WELWYN HATFIELD COUNCIL – DEVELOPMENT CONTROL
DELEGATED REPORT

APPLICATION No:	S6/2007/1008/FP
------------------------	------------------------

PROPOSED FRONT ELEVATION

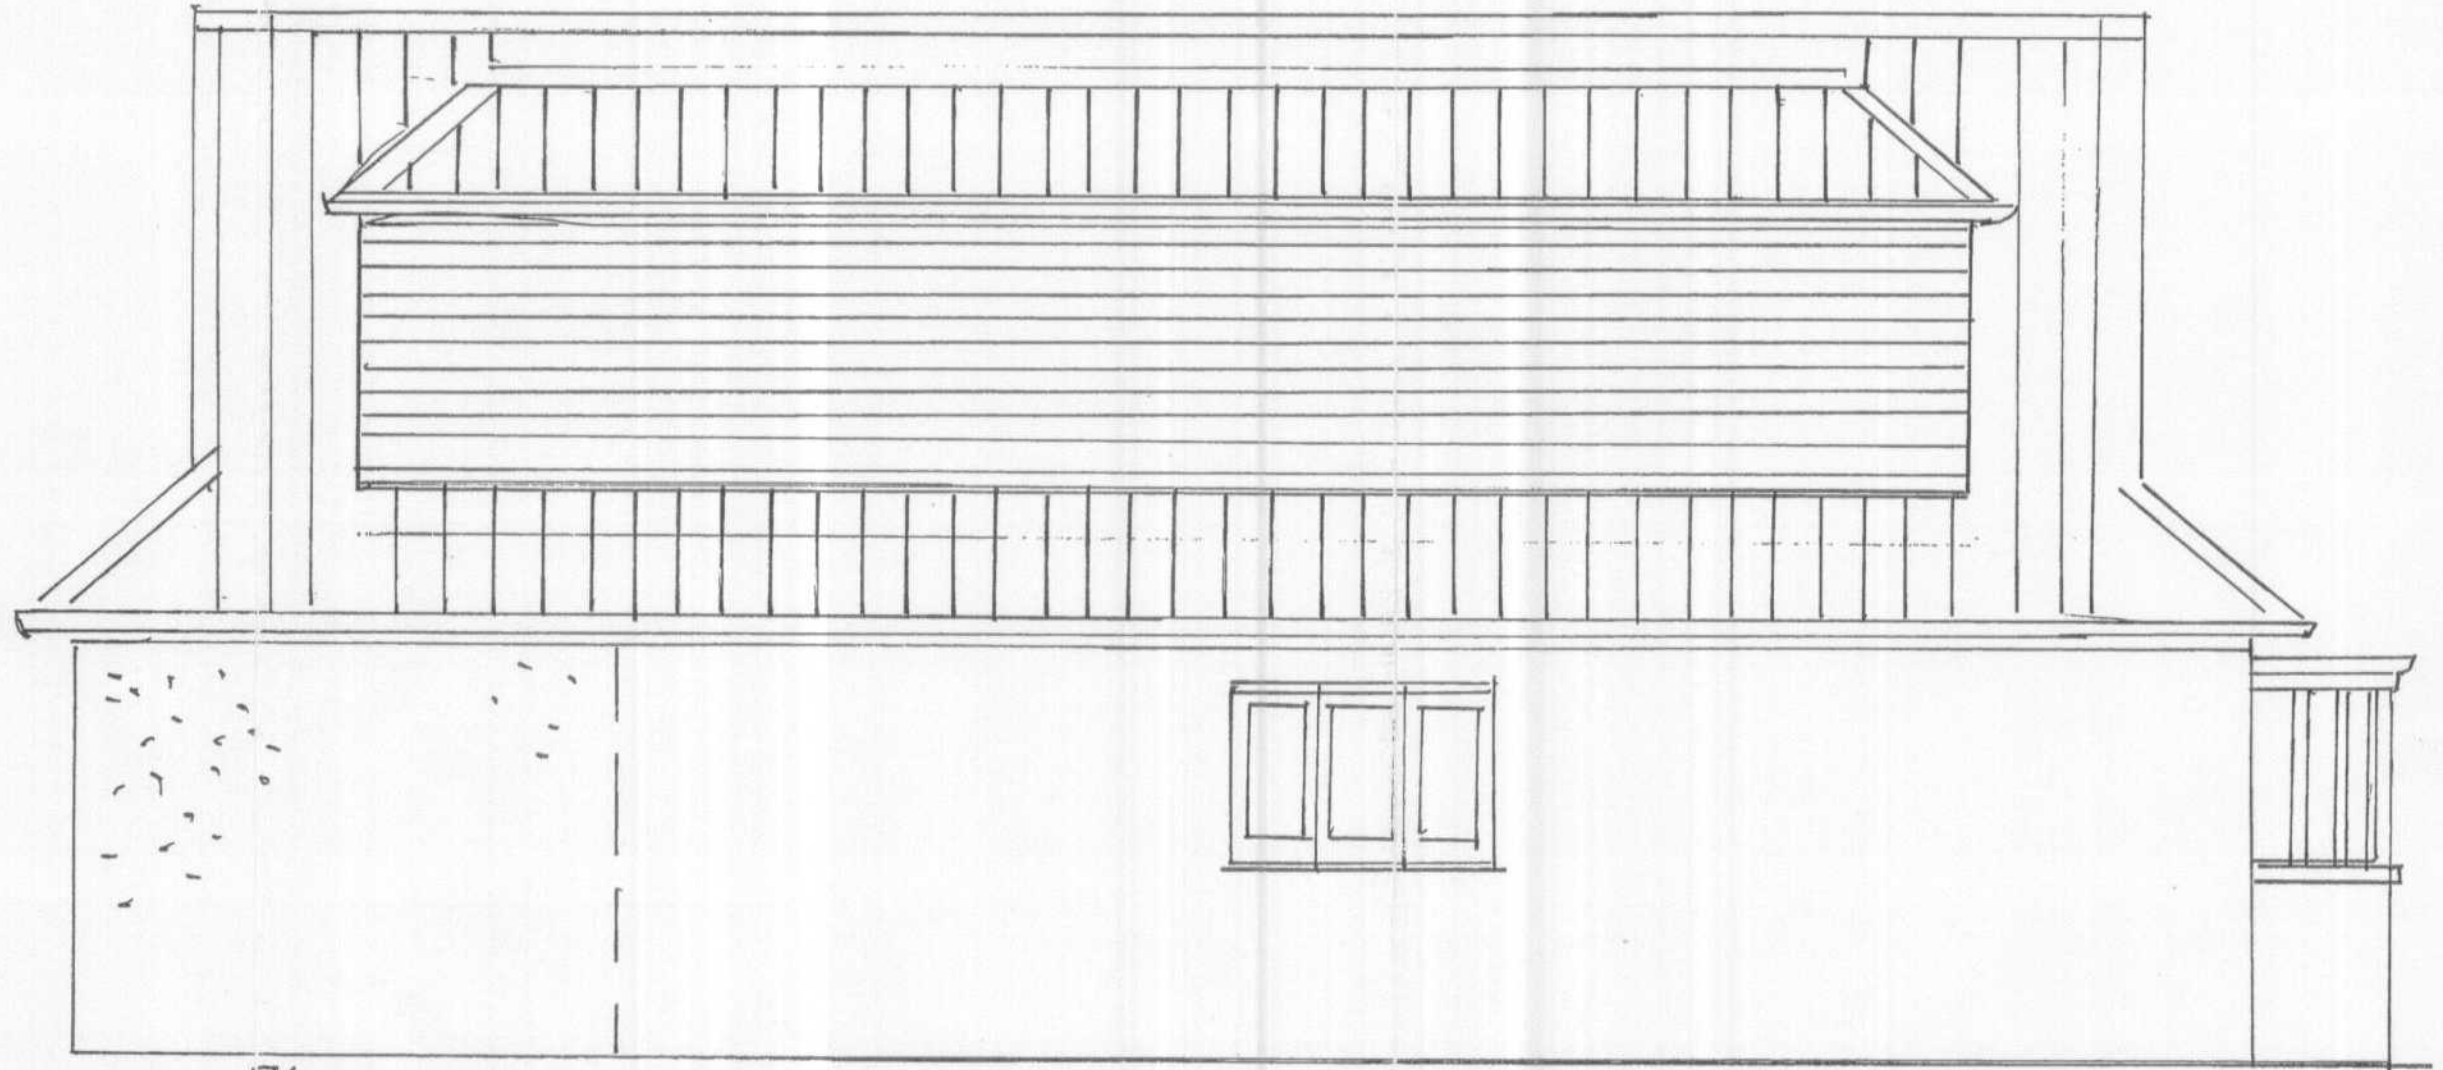
Policy D2 (Character and Context) of the Welwyn Hatfield District Plan 2005, requires that new works respect the character and context of the location. The proposed extension will significantly alter the overall outline and profile of the existing dwelling, so that the dominating feature of the building becomes the large side roof extensions.

In this case the roof extensions are considered not to be subservient to the roof, by virtue of their excessive length, height, and end dimensions. The resultant building would create a surrogate 'first floor' rather than a converted loft area contained mainly within the original roof space. The lack of fenestration provided on the side of the roof extensions creates large dumb areas that further destroy the original simplicity of the roofline of the property. Furthermore, the lack of setback of the side roof extensions from the front gable and hip means that they protrude well forward of the hip line of the original roof, and so results in an unduly prominent feature, harmful to the visual amenity of the streetscape.

In summary, the design of this proposal will alter the style of the building in a way that does not respect the original dwelling and is considered to be at odds with the established character of the streetscene that is predominately of relatively simple hipped roofed bungalows. It is acknowledged that there are examples of chalet bungalows being created by the later addition of for example small side dormers, but they are of a scale that remain subservient to the roofslope and are also not roof extensions, but are indeed dormers.

- 1. The proposal would, by reason of its bulk, visual intrusiveness, design and size of side roof extensions, roof arrangement, and lack responsiveness to its surroundings, result in a visually intrusive and incongruous form of development which would be out of keeping with and detrimental to the character and appearance of the subject site and the street scene generally. The proposal is thereby contrary to Policy D1 and D2 of the Welwyn Hatfield District Plan 2005 and the Supplementary Design Guidance February 2005.

PROPOSED REAR EXTENSION.

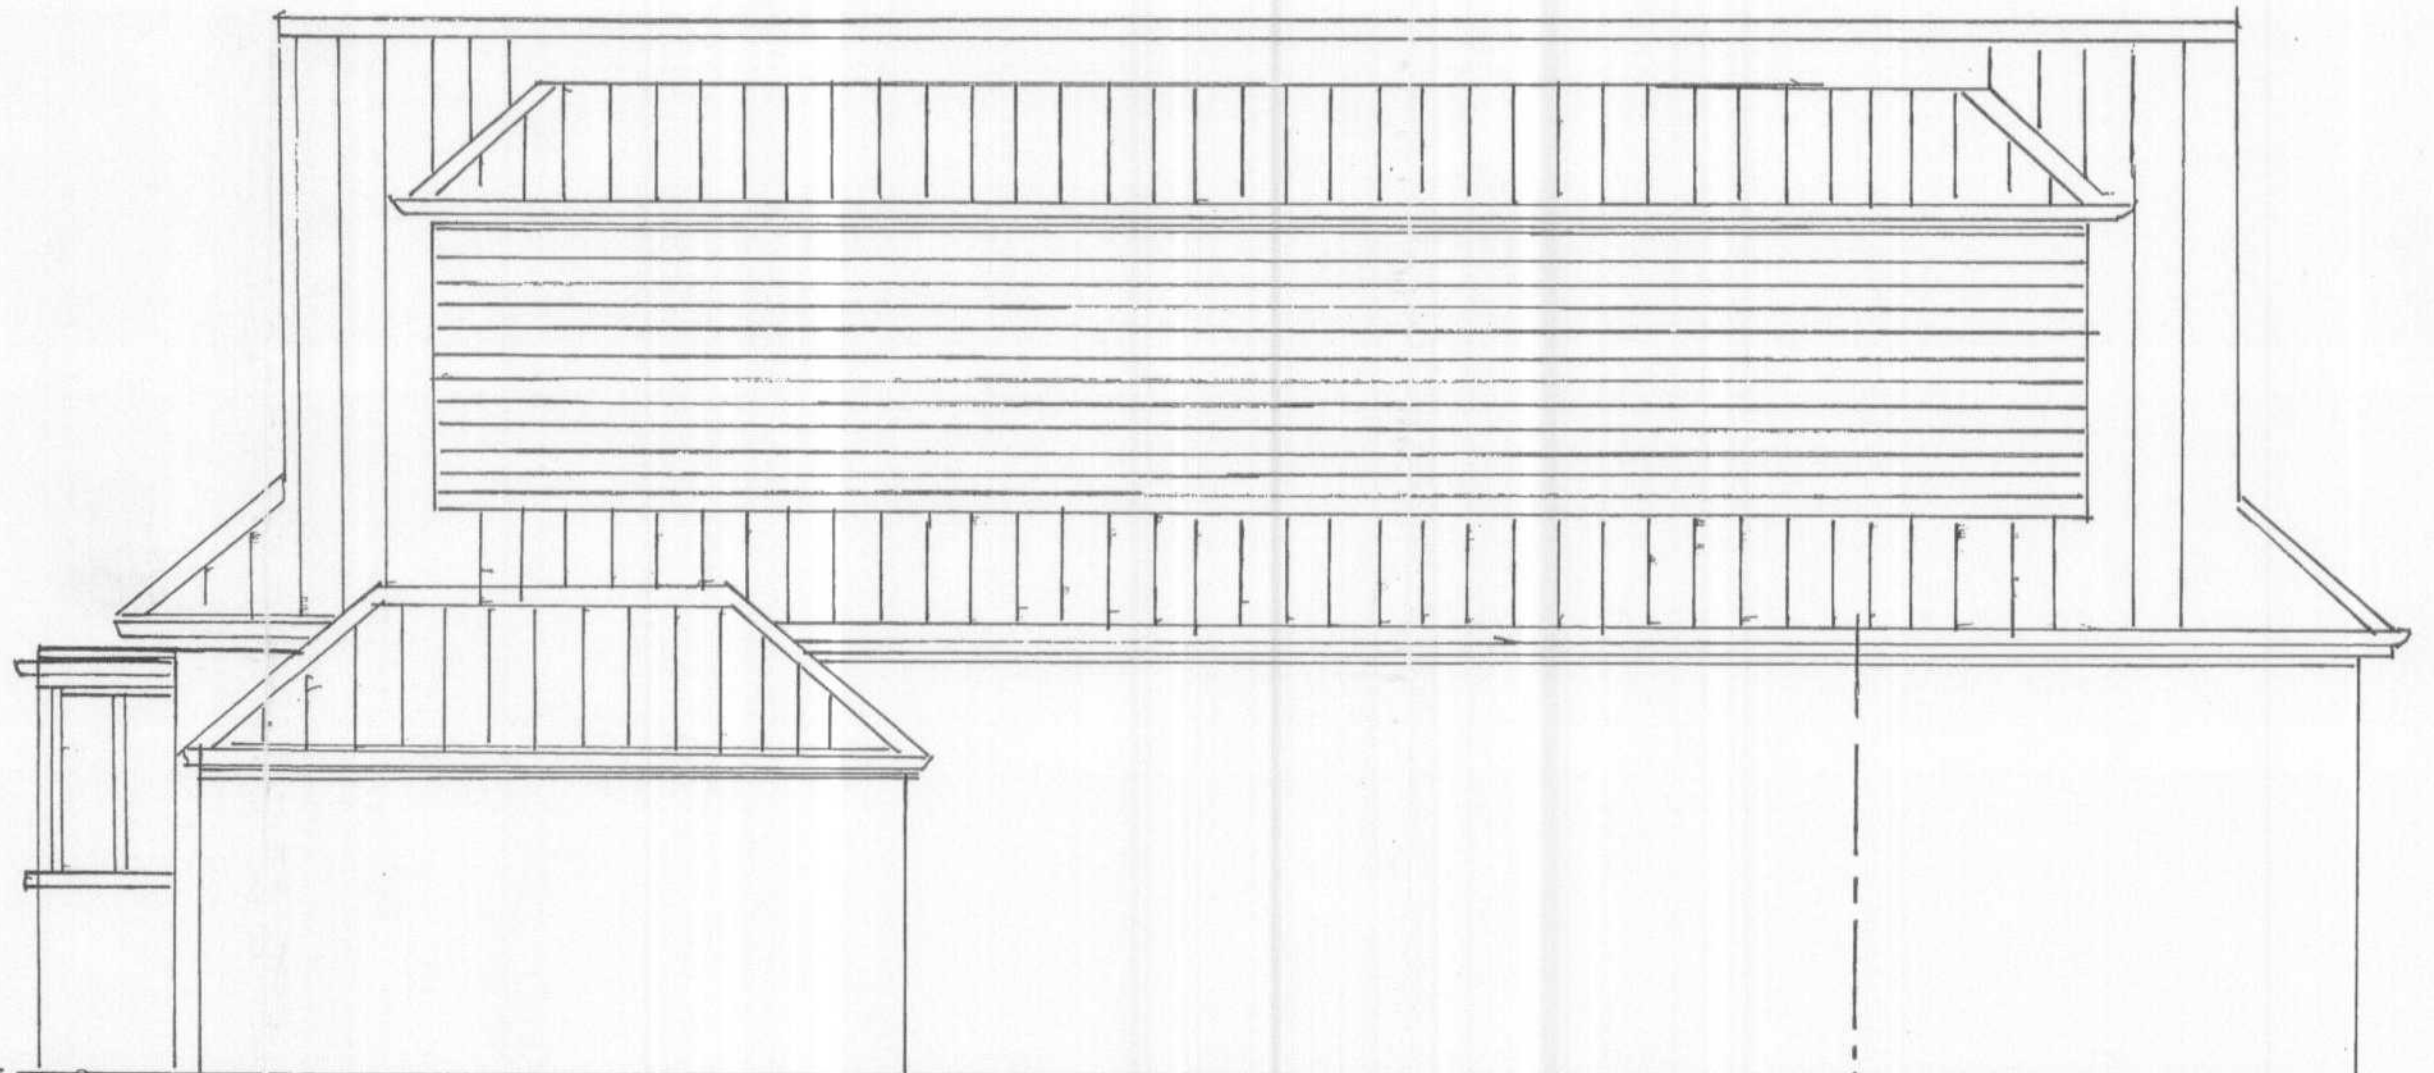
It is proposed to extend the ground floor to the rear by 3.6m across the full width of the property with a pair of full height double glazed doors in the rear wall.

As the plot has a north-south alignment, some loss of light to adjoining properties is likely to occur to Number 25 (to the west) in the morning and Number 21 (to the east) in the evening from the proposed rear extension and associated roofing, but there would still maintain sufficient sunlight/daylight to these neighbouring properties.

Proposed First Floor.

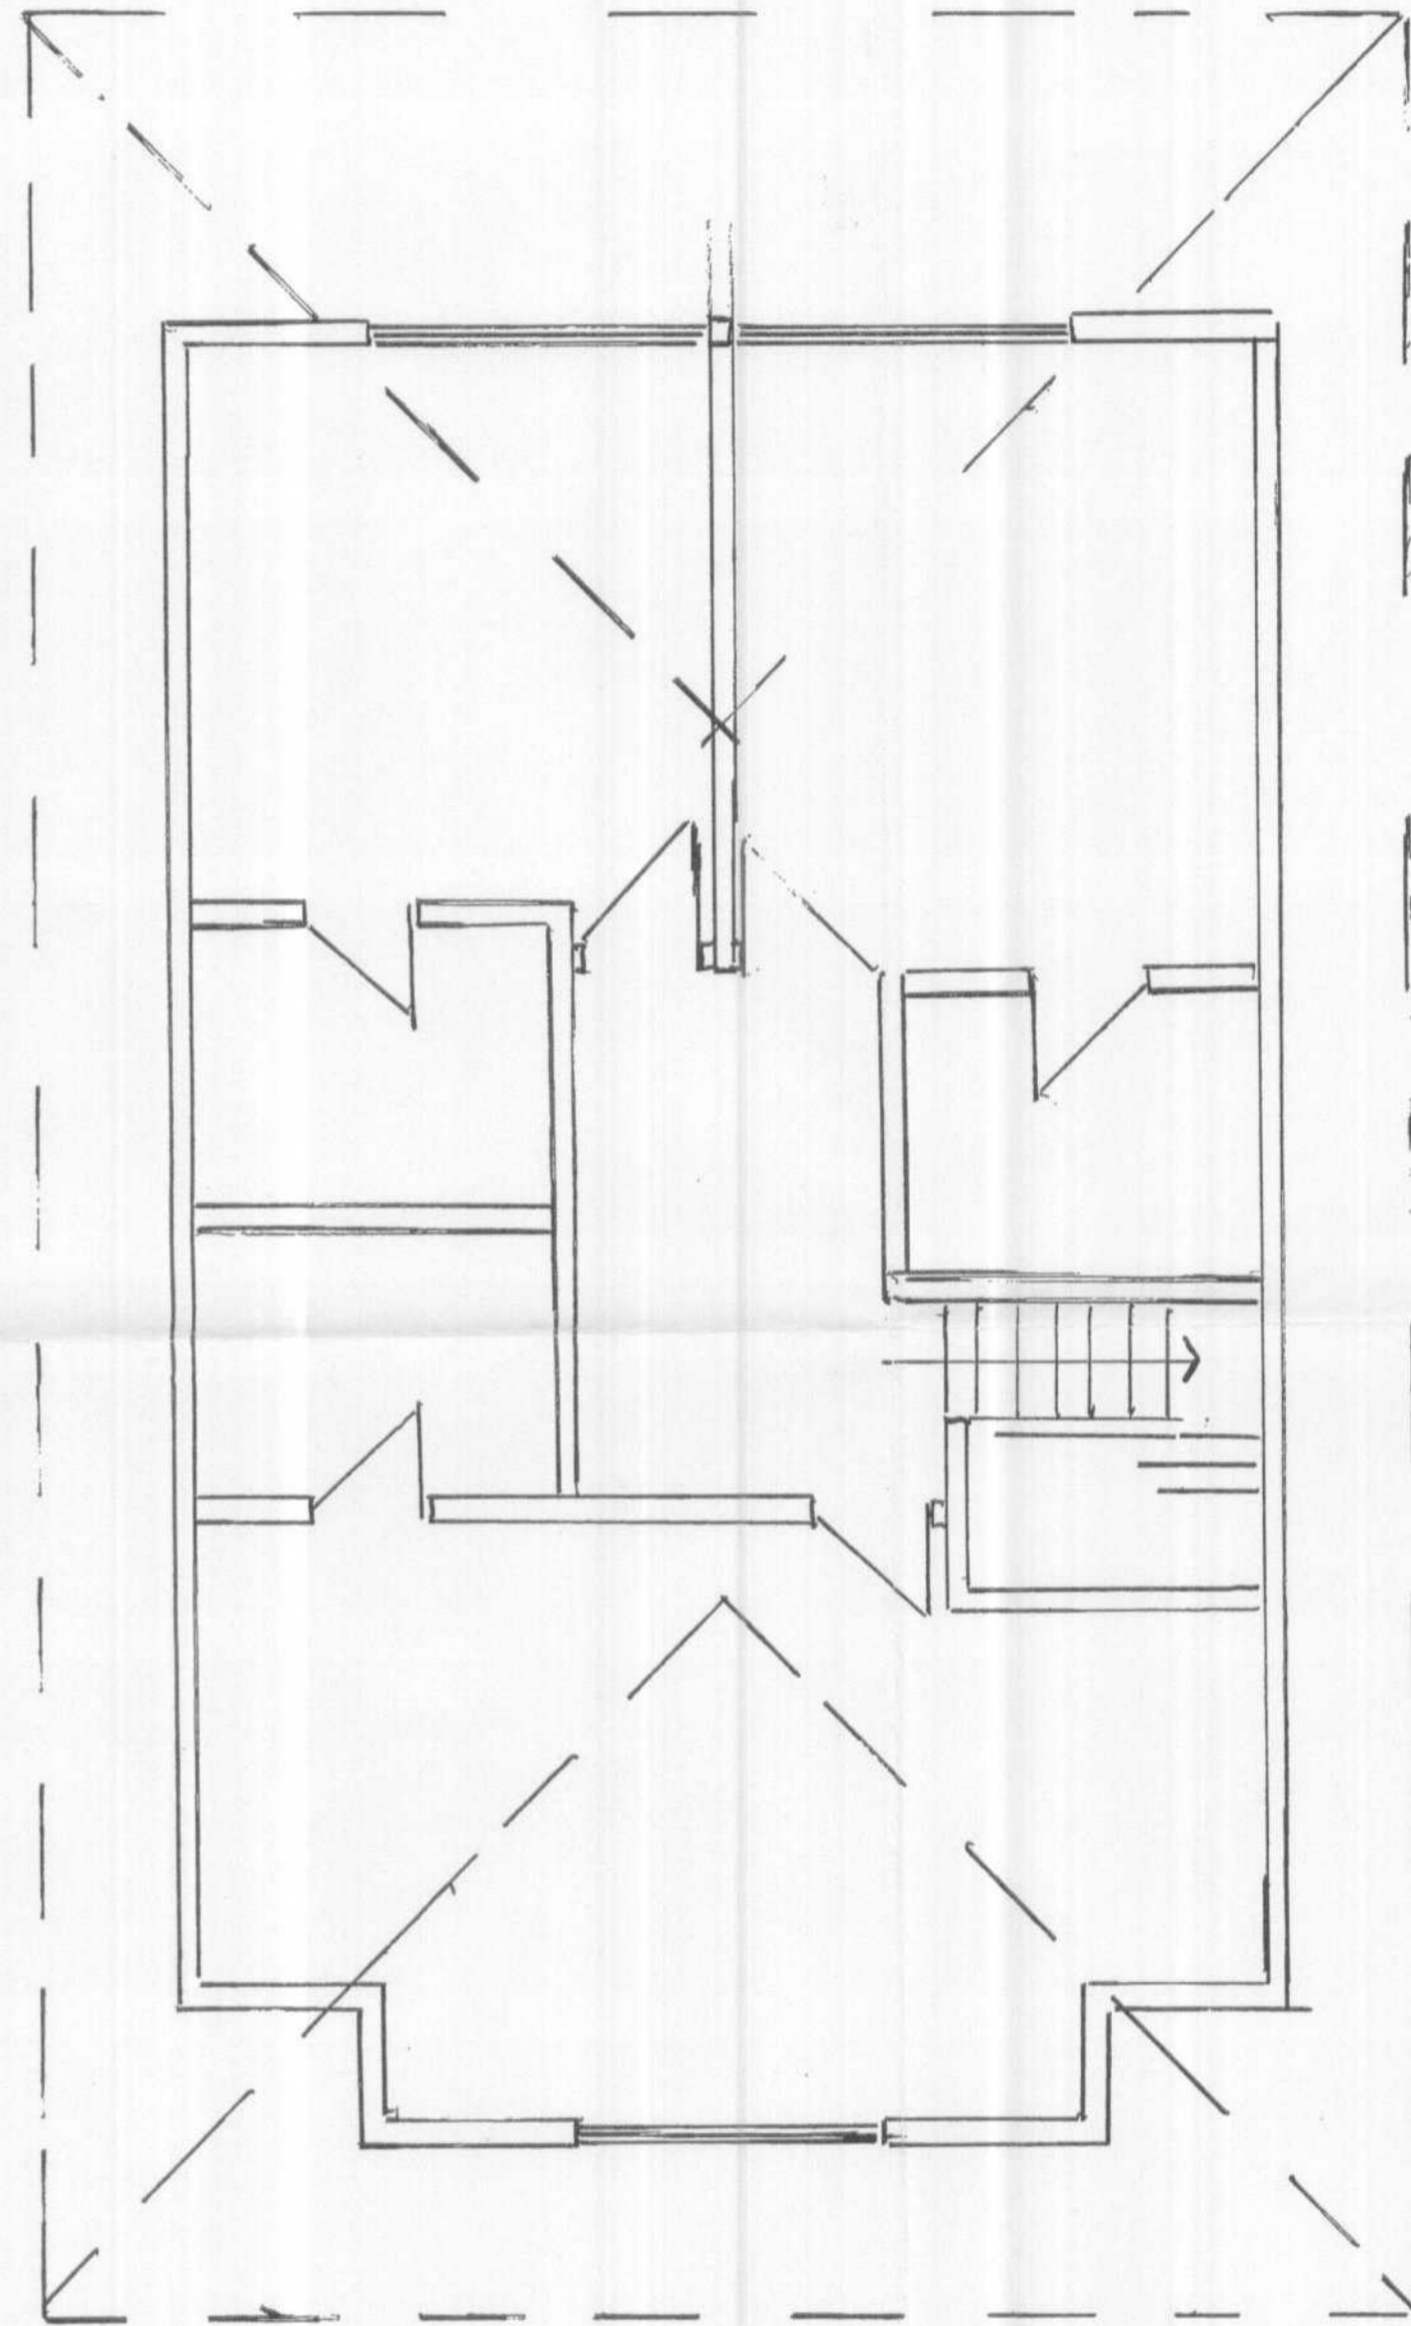
At first floor level it is proposed to create habitable accommodation by altering the roof configuration which involves increasing the height of the existing ridge line by approximately 0.5metres. In addition part front and part rear gable end walls along with roof extensions to the side roofslopes are proposed. The only new windows at first floor level are shown in the front and rear gable end walls.

This would provide accommodation for 3 bedrooms, and 3 smaller rooms which are likely to be bathrooms.

The materials proposed are specified are tiles for the roof, but it is unclear what is proposed for the side extensions. A mixture of brick and render proposed on the new wall areas although the exact location is unclear from the drawings. These materials are generally acceptable in matching the existing finishes, although clarification in regards to the material used in the proposed roof extensions is required.
